EF13/5058, DOC17/332423-01
SSD 7610

SSD 7610 – INNER SYDNEY HIGH SCHOOL – EIS

ATTACHMENT A
- ENVIRONMENT PROTECTION AUTHORITY COMMENTS -
INNER SYDNEY HIGH SCHOOL

1 PLAN Level 4 Games Terrace
1:200

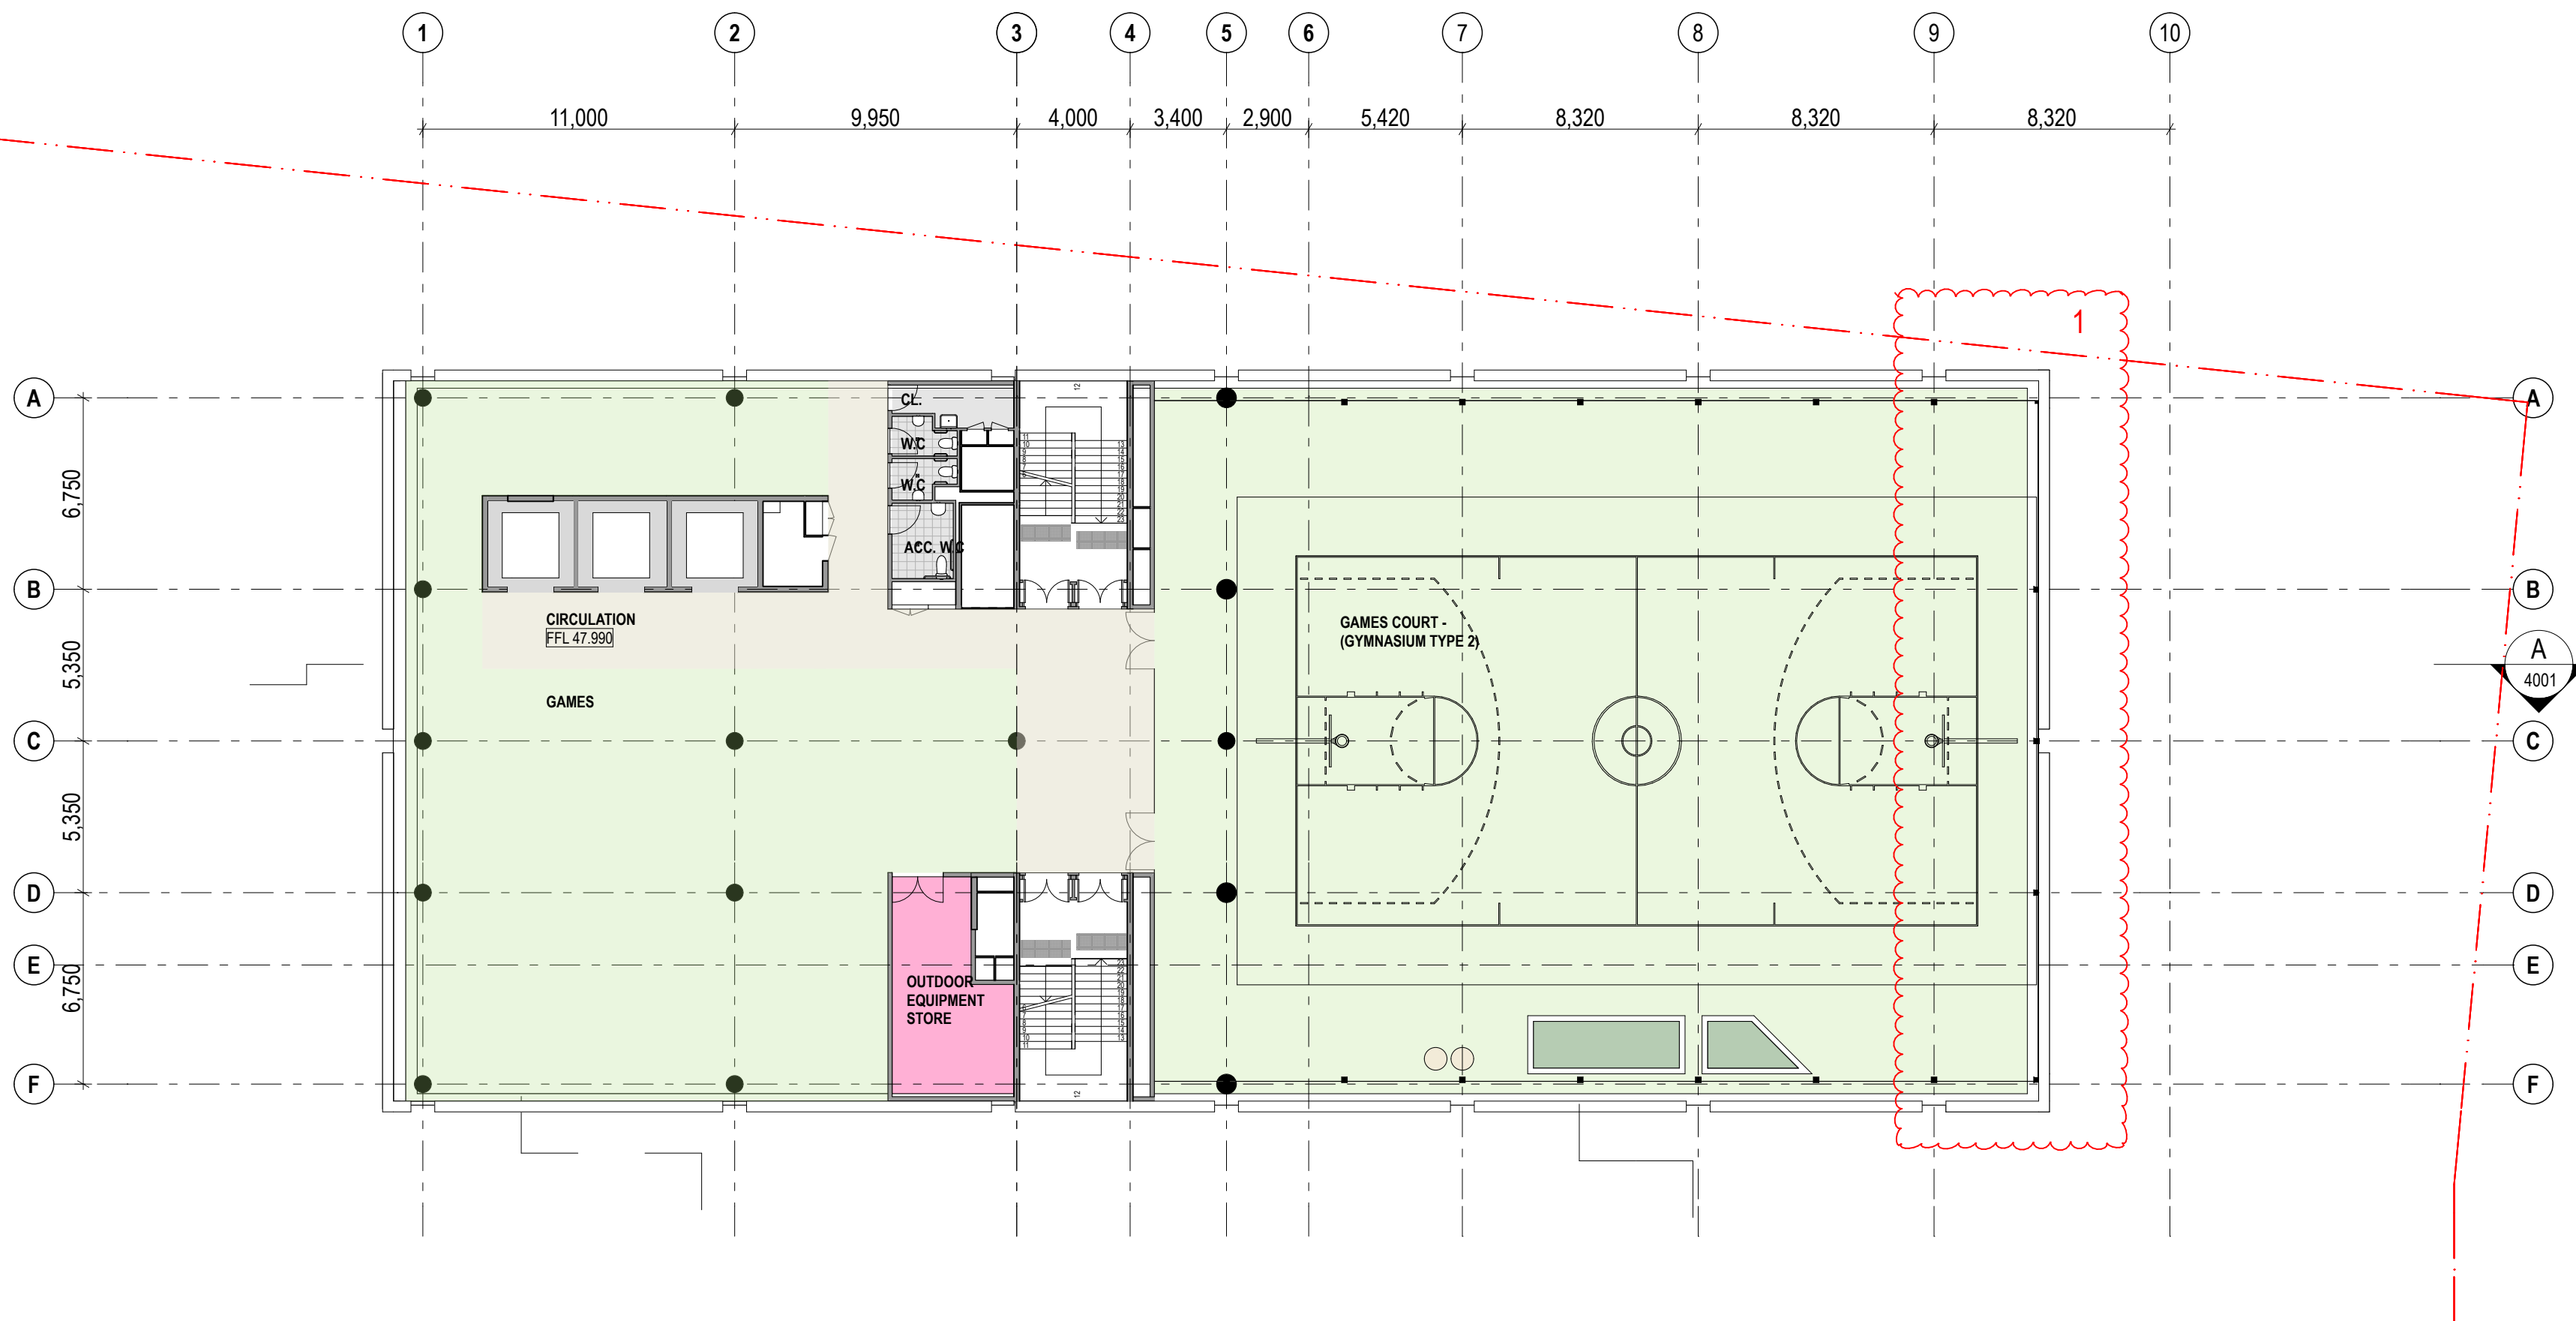
The EPA considers the proposed community use of school facilities (especially the rooftop basketball court) outside normal school hours needs to be carefully managed to ensure noise impacts on nearby residences are minimised.

The proponent be required to ensure implementation of all feasible and reasonable noise mitigation and management measures, including but not limited to:
